GORT PUBLIC REALM ENHANCEMENT PROJECT

AN COIMISIUN PLEANALA CASE NO. 323066-25

**GALWAY COUNTY COUNCIL RESPONSE TO
OBSERVATION BY:**

J SULLIVAN & TTRSA

DRAWING TITLE
LANDSCAPE GENERAL ARRANGEMENT

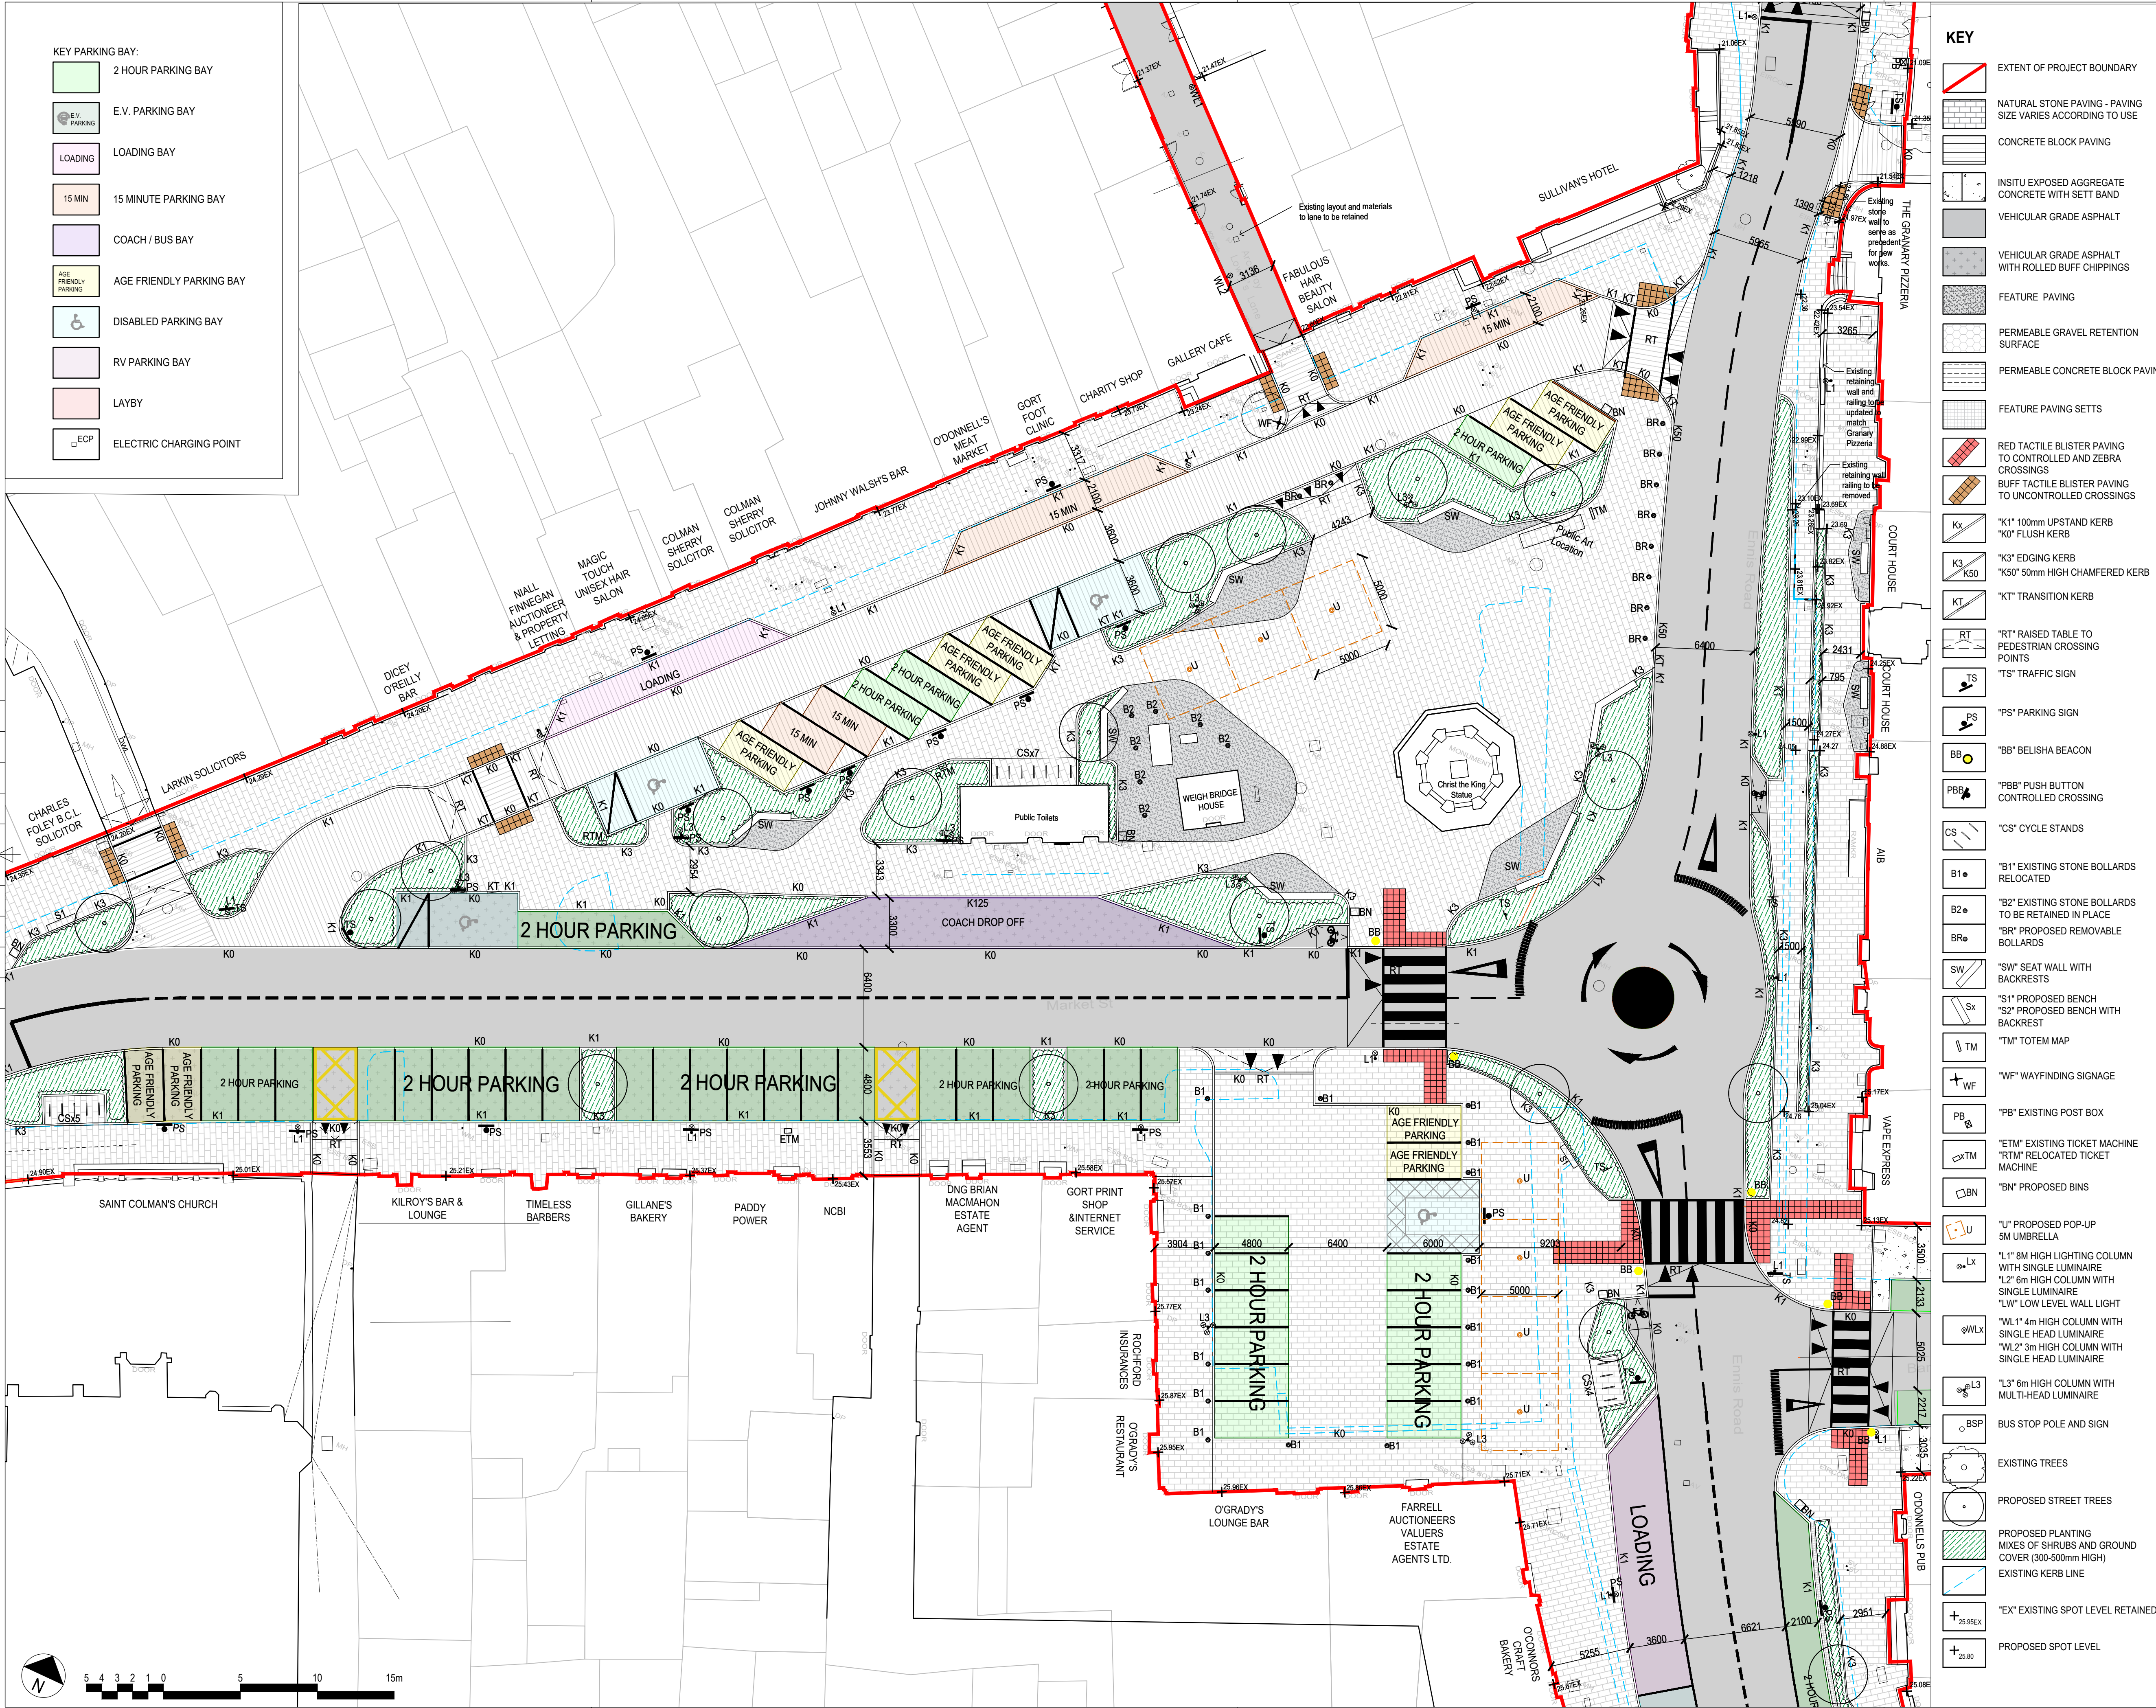
Currently there is no safe pedestrian crossing point in front of the hotel due to the public parking arrangement which is situated directly on the desire line at the junction of the R458 and R460 (Photo 1). This parking arrangement causes significant traffic management and pedestrian safety issues (Photo 2, 3 & 4).

The Galway County Council design proposal seeks to provide safe pedestrian access, manage traffic at the junction of the R460 and R458, and provide dedicated age friendly bays along a service access road which will incorporate passive traffic calming measures. In addition to this the realignment of the R460 to R458 junction in front of the hotel will make it safer for all road users. The dedicated access road is required by Sullivans Hotel delivery vehicles as they currently stop on the R458 (photo 2) which presents a serious danger to all road users as evidenced below.

The current arrangement of the public parking to the front of Sullivan's Hotel eliminates the possibility for the provision of a pedestrian crossing on the desire lines posing a significant danger to all road users

Extract from the submitted drawing DR-L-0103 illustrating the pedestrian priority access road, pedestrian crossing at the desire line, drop-off zone in front of Sullivan's Hotel, age-friendly parking, and the realigned junction at the R458 at Gort Market Square.

The Galway County Council proposal is a response to an existential danger which must be addressed through the considered realignment of the busiest junction in the town along with the allocation of age-friendly and accessible parking. The provision of a dedicated, pedestrian priority access road will remove the current danger posed by delivery vehicles having to park illegally.
